Rezoning Transportation Analysis

Petition Number: #2021-277

Date	Description
05-18-2022	First Review (WB)
09-21-2022	Second Review (AO)
10-26-2022	Third Review (IW)

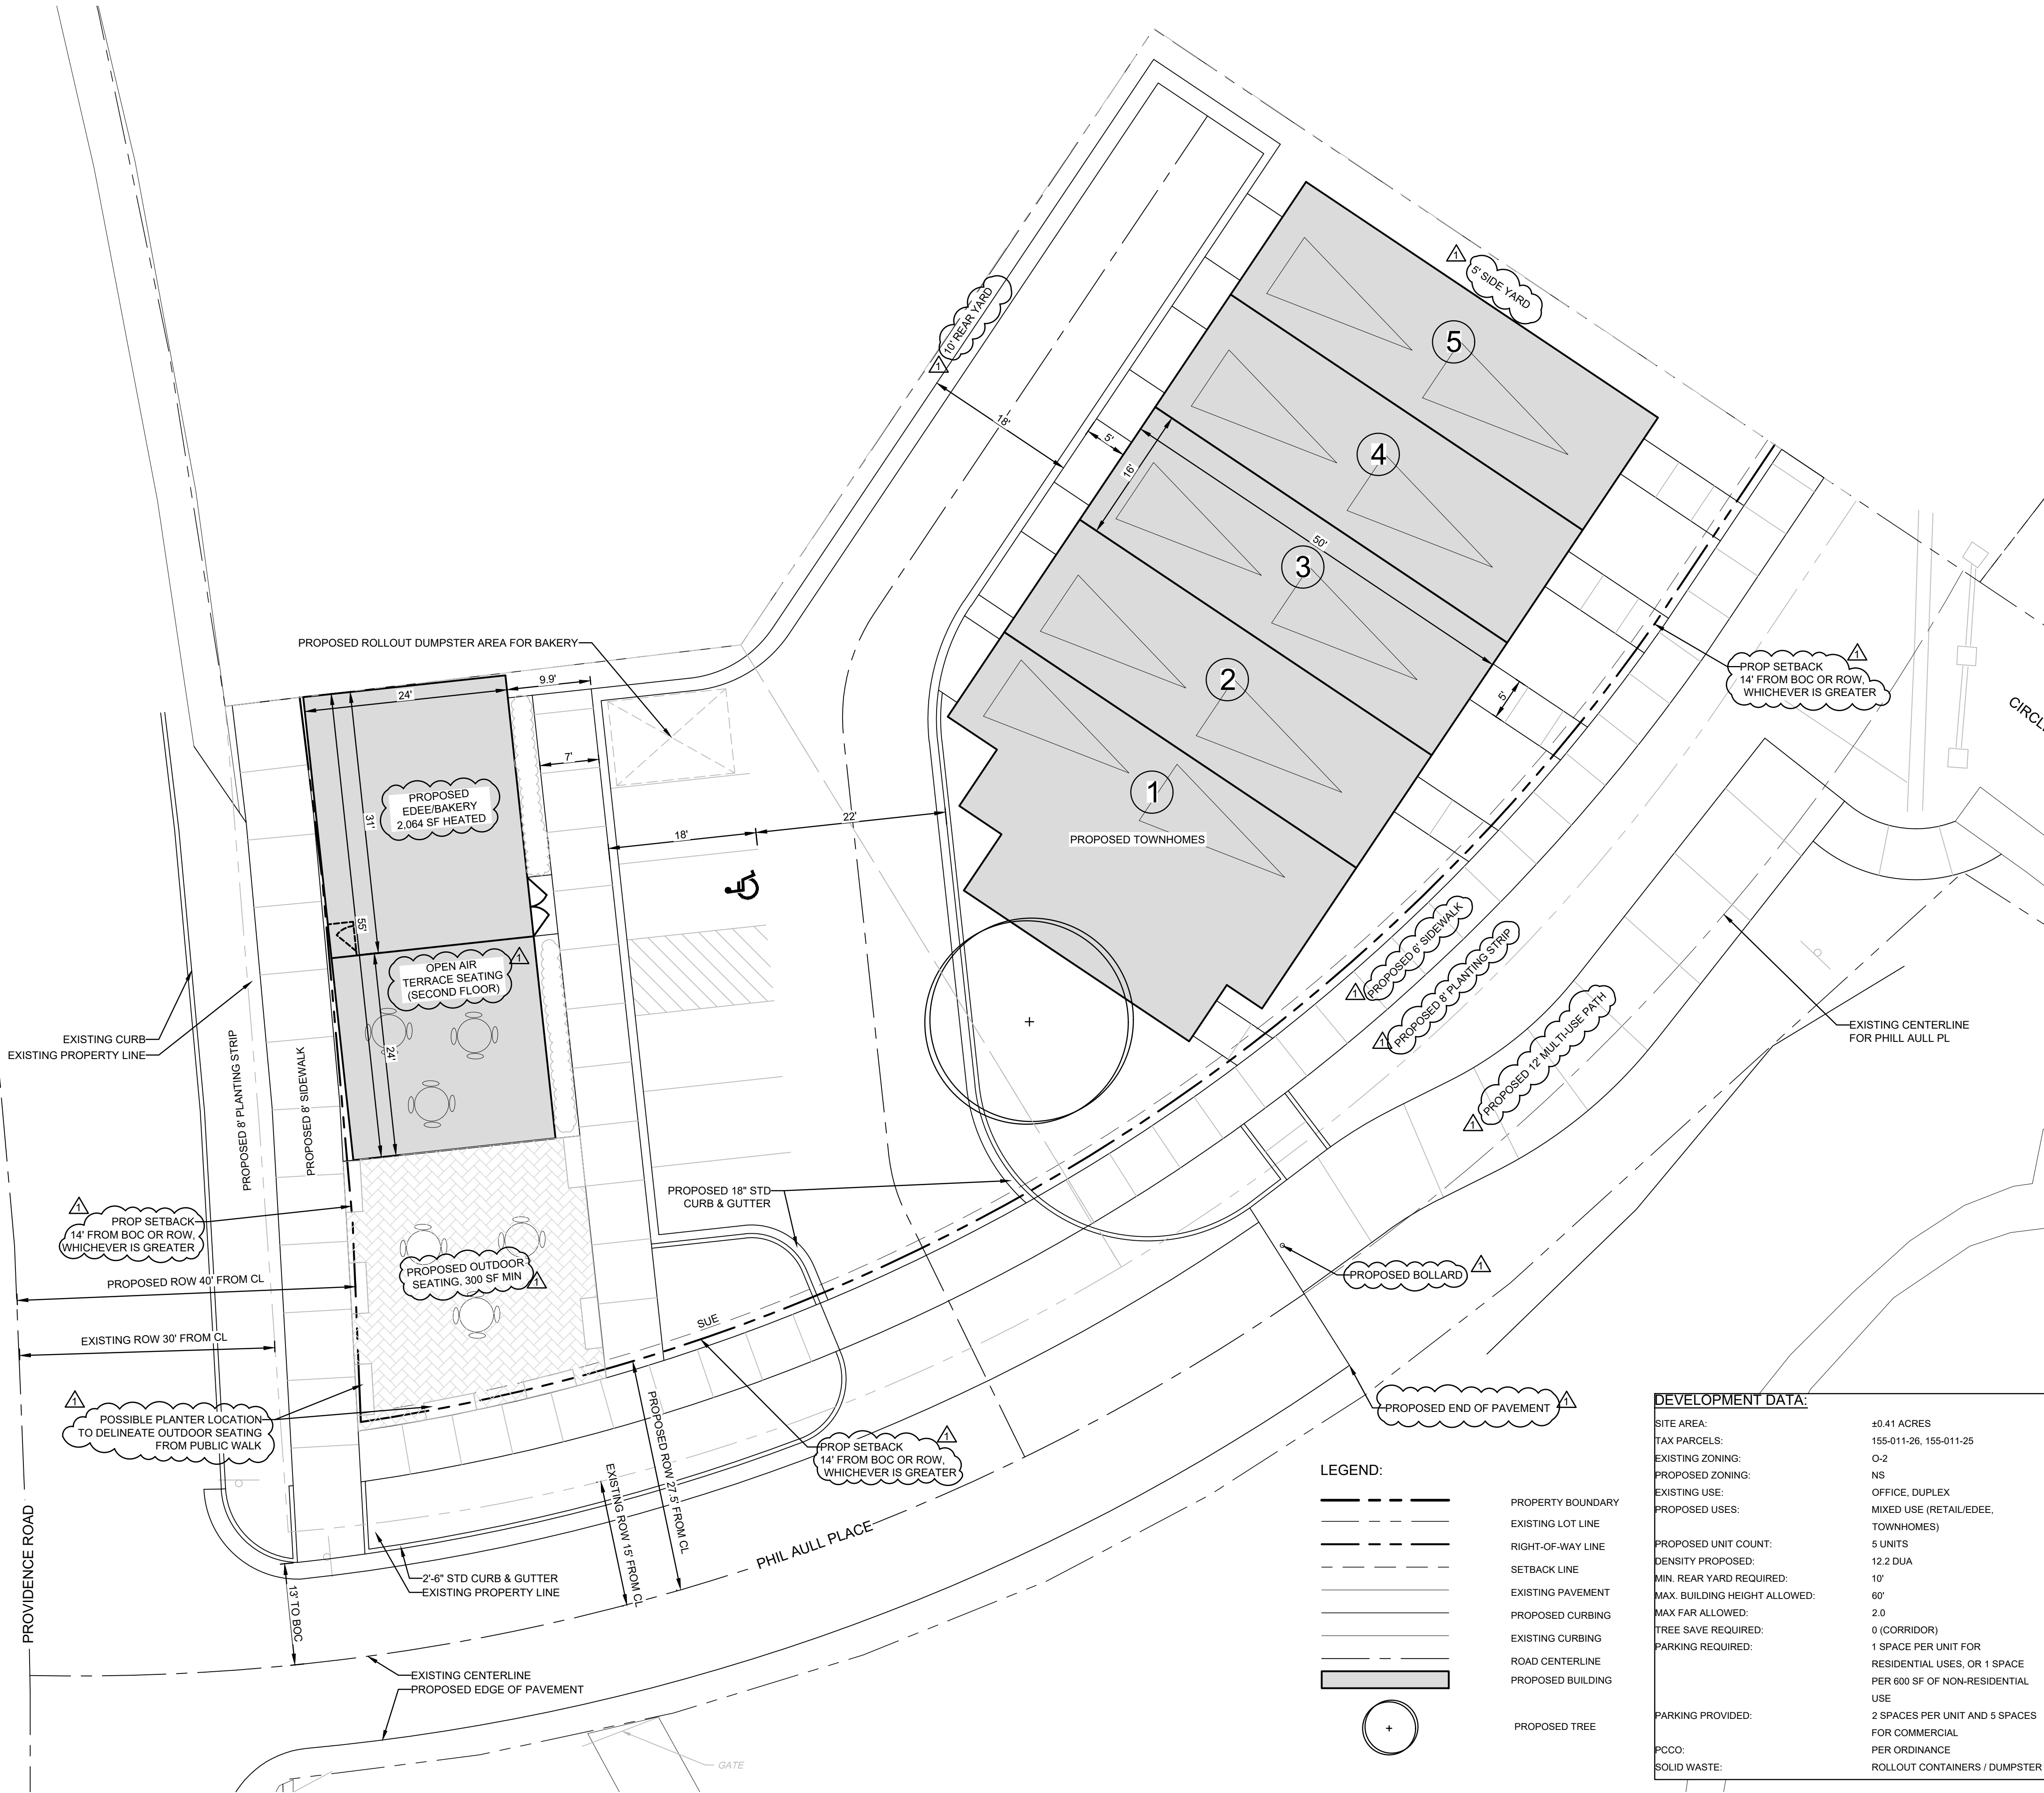
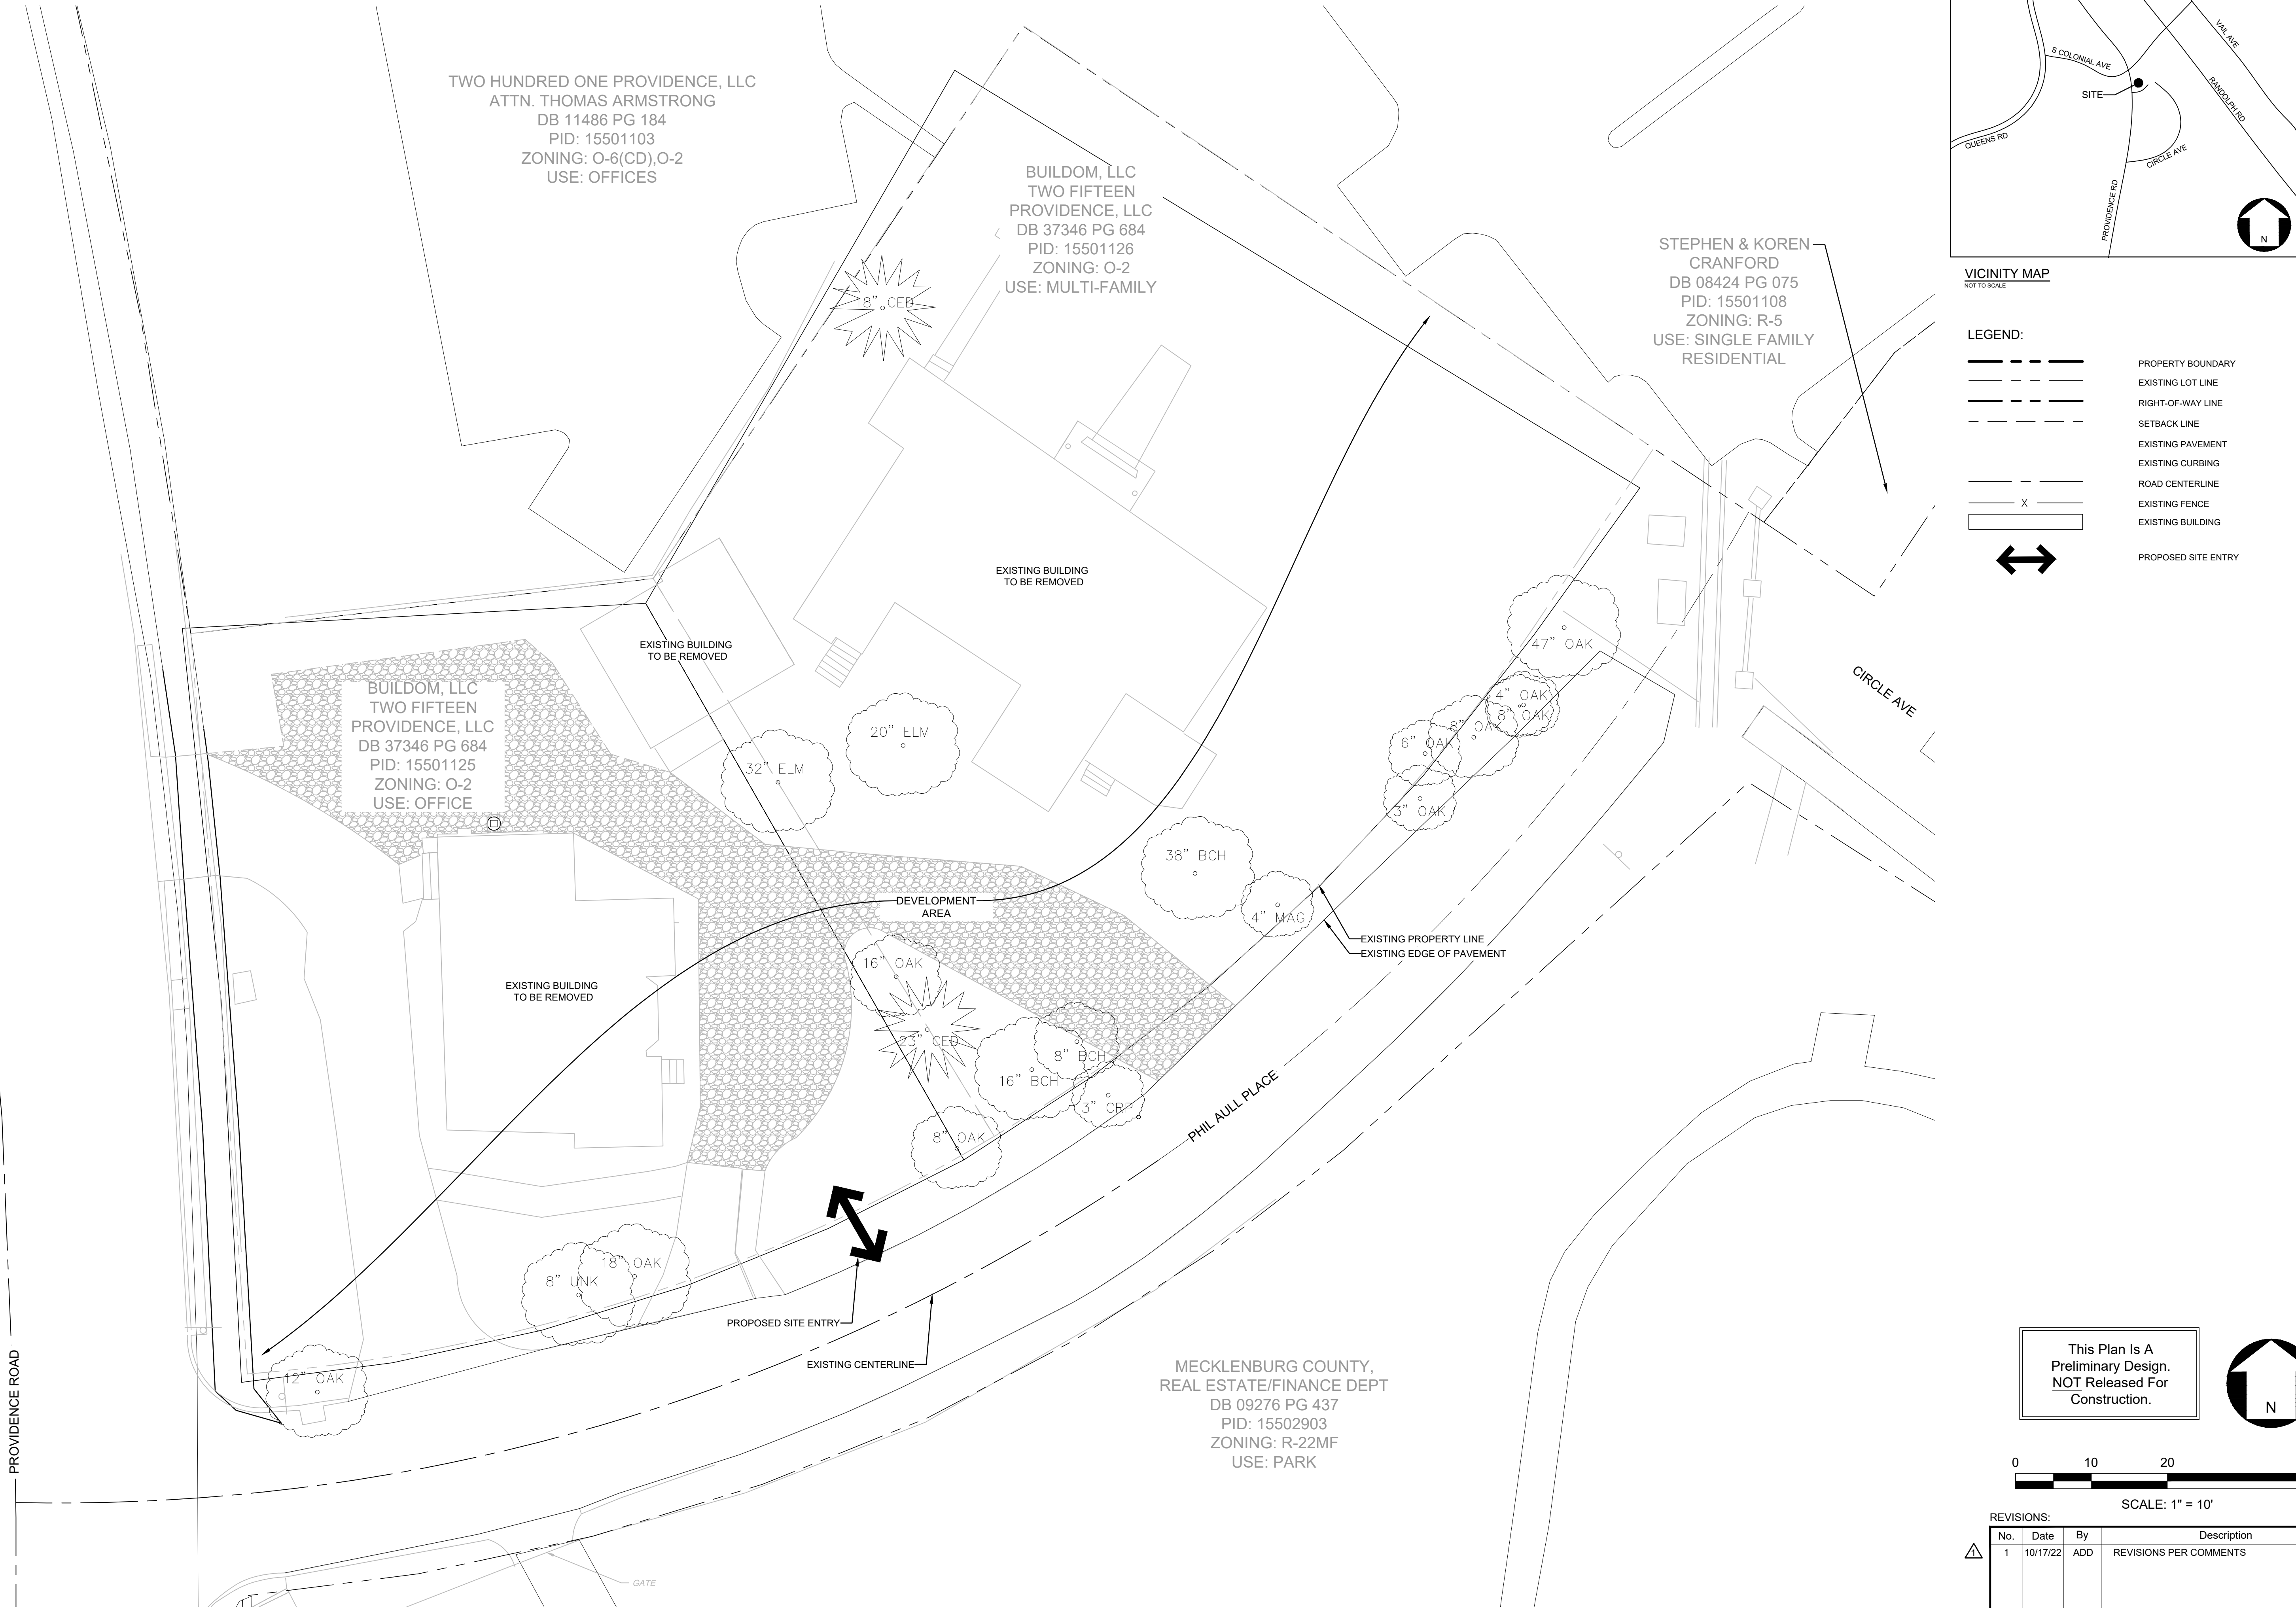
3. ~~Outstanding Comment from 5-18-22:~~ Revise site plan and conditional notes to commit to dedicate 40 ft (min) right of way from the Providence Road centerline. Provide a sidewalk utility easement (SUE) 2 ft behind the future back of sidewalk (50.5 ft from the centerline). The site plan shall label and dimension the right of way from the road centerline.

Clarifying Comment from 10-26-2022: Provide and show sidewalk utility easement (SUE) 2-ft behind the future back of sidewalk (50.5-ft from the centerline) on Providence Road.

6. **Outstanding Comment from 5-18-22:** Site plan and conditional notes revisions are needed to provide an ADA compliant pedestrian connection from Phill Aull Place to Circle Avenue.

Clarifying Comment 10-27-22: Label and add conditional note committing to ADA compliant connection.
